Consultation Response from KC, Lead Local Flood Authority
2022/93377 Corn Mill Bottom, Long Lane, Shelley, Huddersfield, HD8 8JJ
Erection of one dwelling and associated landscaping and parking, demolition of existing agricultural building
Date Responded: 4th April 2023 Responding Officer: Paul Farndale Responding Ref:

Kirklees Flood Management and Drainage continues to OBJECT to this application as the site coincides with flood zone 3.

Site Plan as 'Proposed'

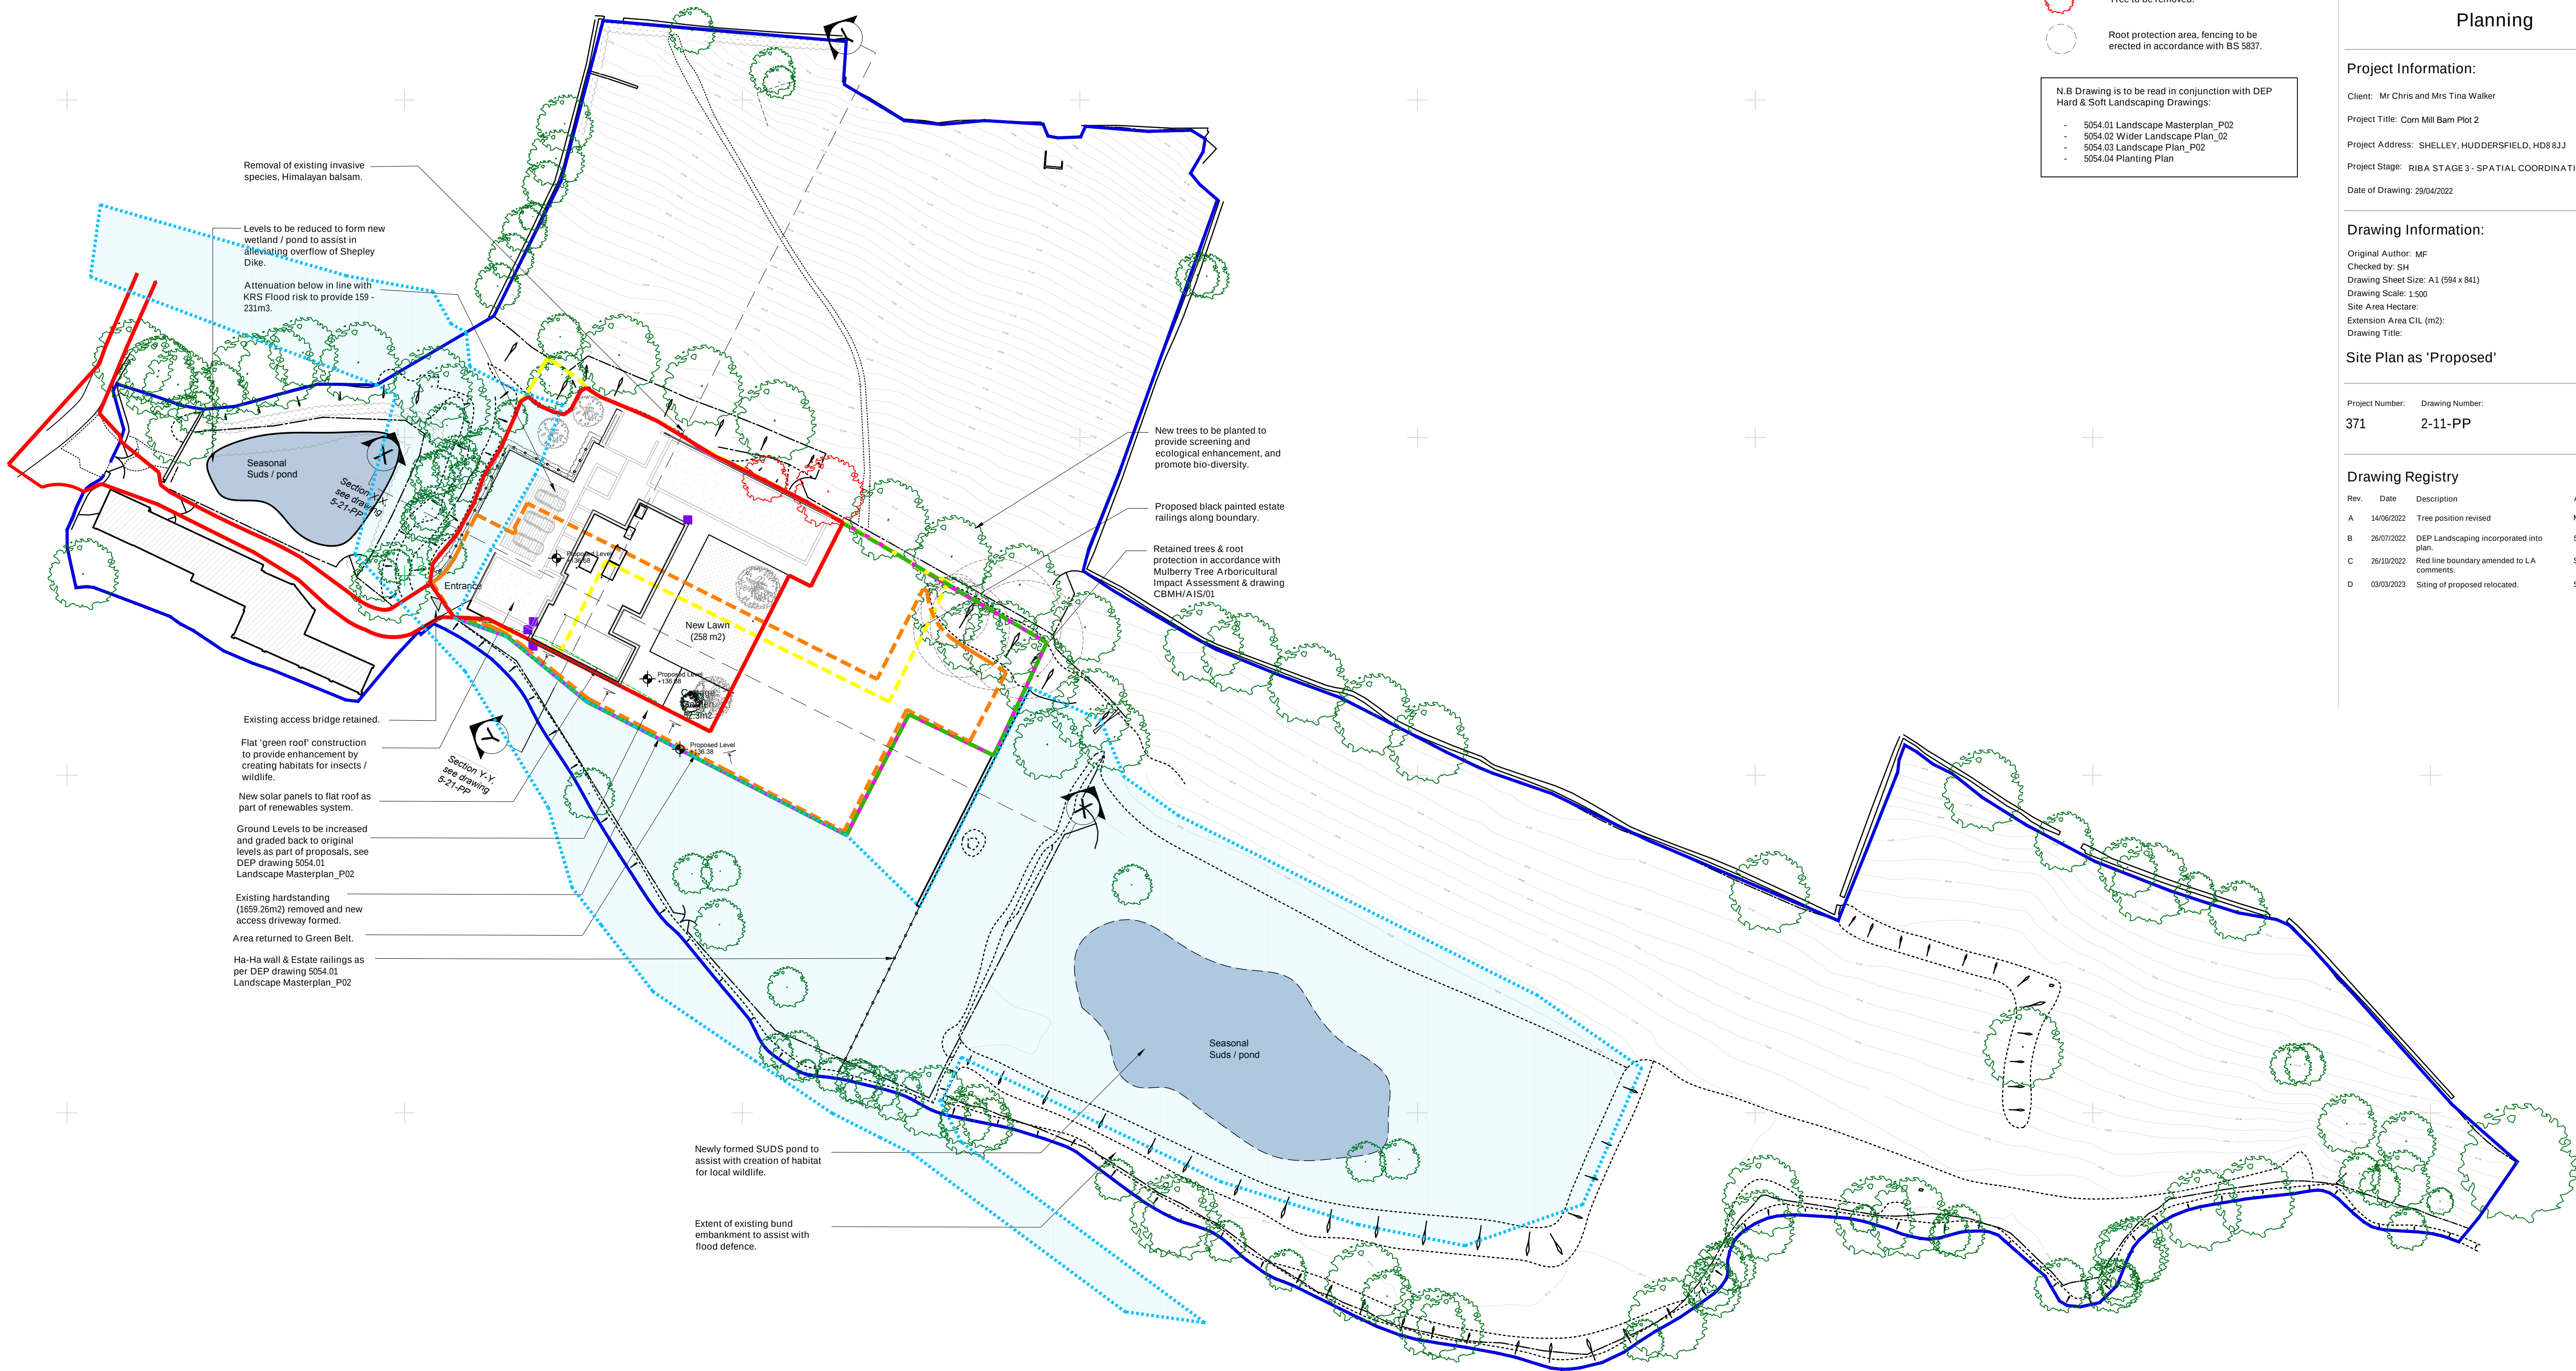
The blue line boundary may offer scope to deliver a property in flood zone 1 within the site, i.e. a **SEQUENTIAL APPROACH**. Such an approach with accompanied by an accepted flood risk assessment would result in a reconsideration of our current stance.
